5 November 2019

**International Chinese School (SSD-10260)
Response to Submissions**

ATTACHMENT 1

Figure 15 | Site Plan (Source: Applicant's SRTS)

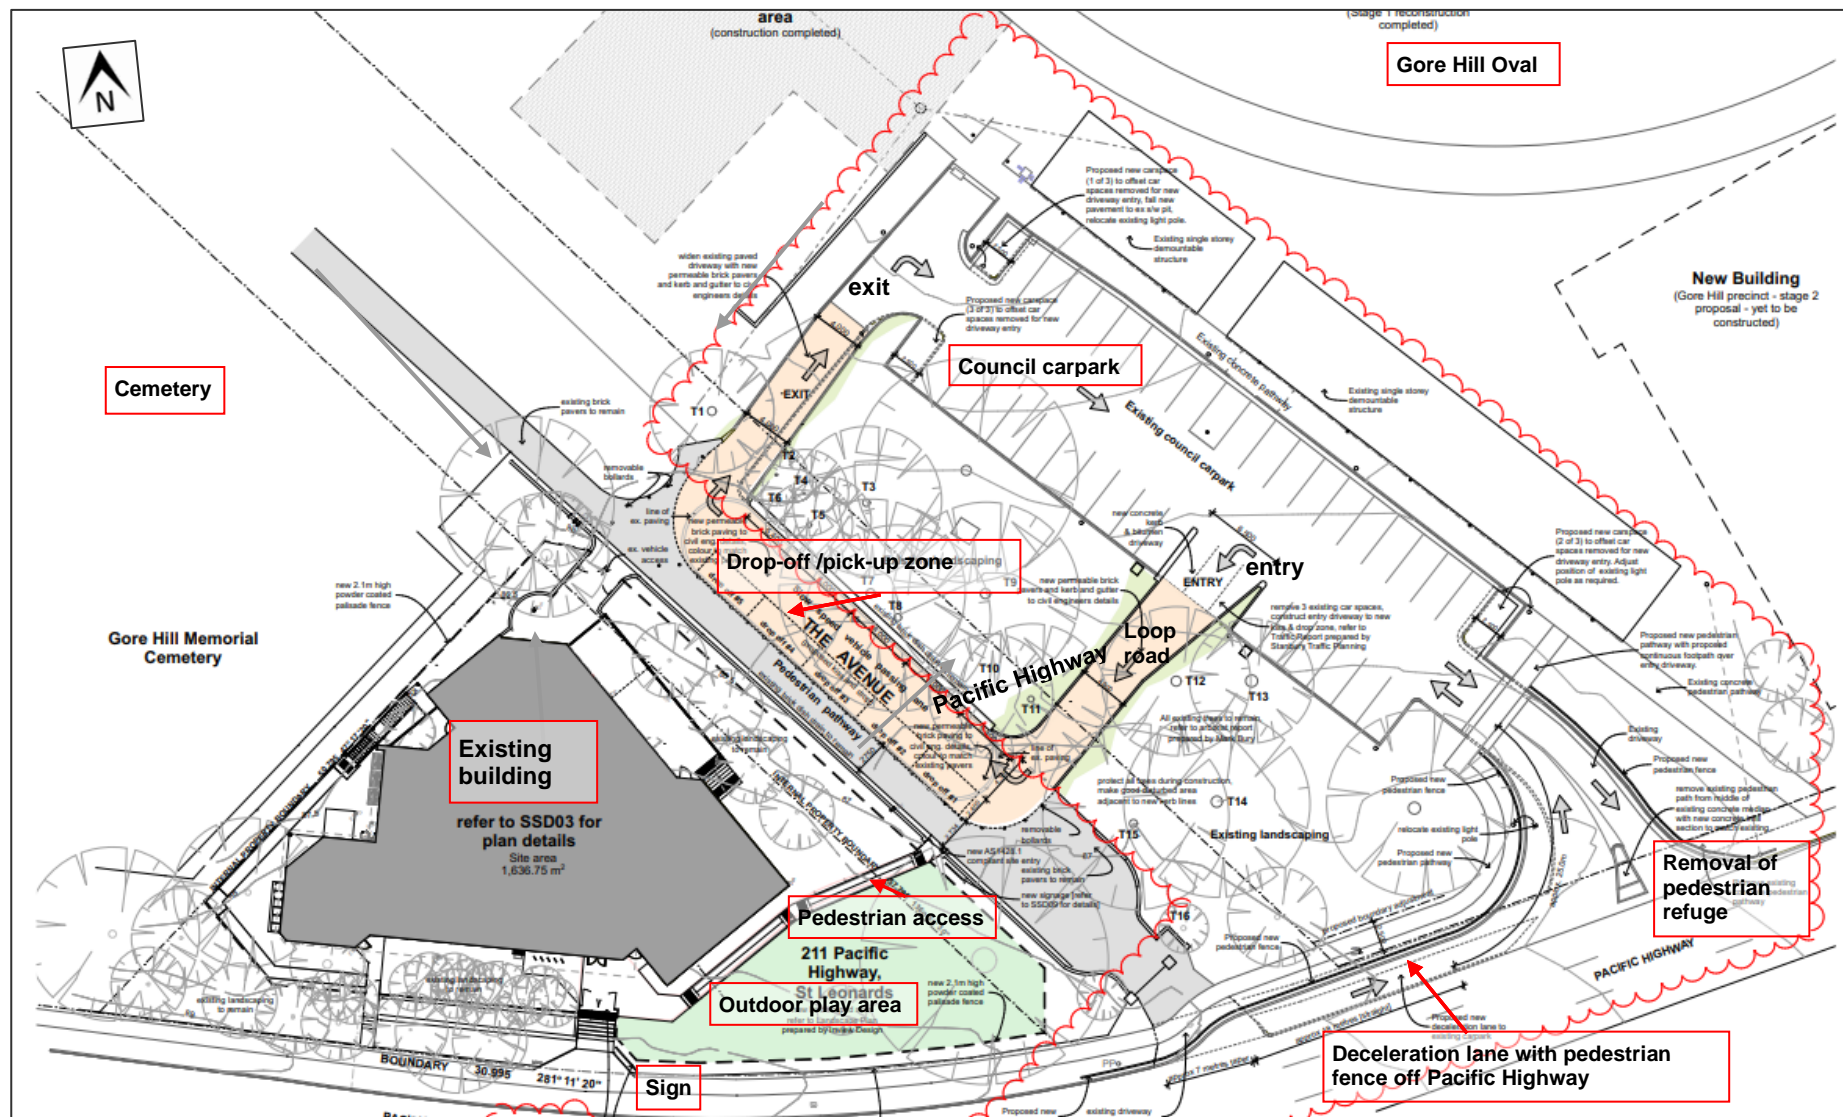
- The Department considers that the extent of proposed paving for the five 'Kiss and Drop' spaces shown on drawing No. SSD01 and its proposed charcoal colour would significantly alter the appearance and visual consistency of The Avenue resulting in significant impacts on the physical and visual character of the state heritage item. The Department is concerned that the Heritage Impact Statement (HIS) prepared by 'NBRS Architecture' has not accurately ascertained the extent of new paving proposed and has not therefore provided a proper assessment of heritage impact. The Avenue currently contains a combination of paving, soft gravel and grass in uniform proportions along the majority of its length towards to north. Drawing No. SSD01 incorrectly notates the area of soft gravel and grass adjoining the pedestrian pathway as 'line of existing paving'. The HIS states that proposed works include "re-laying of existing paving". This description is inaccurate as the soft gravel and grass is proposed to be replaced with charcoal coloured paving bricks, resulting in a fully paved area between the school site and Council car park which significantly departs from the character of the ground surface treatment along the remaining length of The Avenue. Further, although indicated on drawing No. SSD01, the EIS has not discussed the proposed paving works to The Avenue in full detail.

- A second building identification sign is shown on drawing No. SSD01 to be constructed adjacent to the pedestrian entrance on The Avenue. The EIS and HIS document one sign only and the second sign facing The Avenue has not been considered in the HIS or

EIS with respect to its visual impact to the state heritage item. Further, the sign appears to be located in an area which is currently provided with dense shrubs. Clarification of the number of signs proposed and the potential heritage impact of an additional sign facing the Avenue should be addressed in the RtS. This should include any details of vegetation impact.
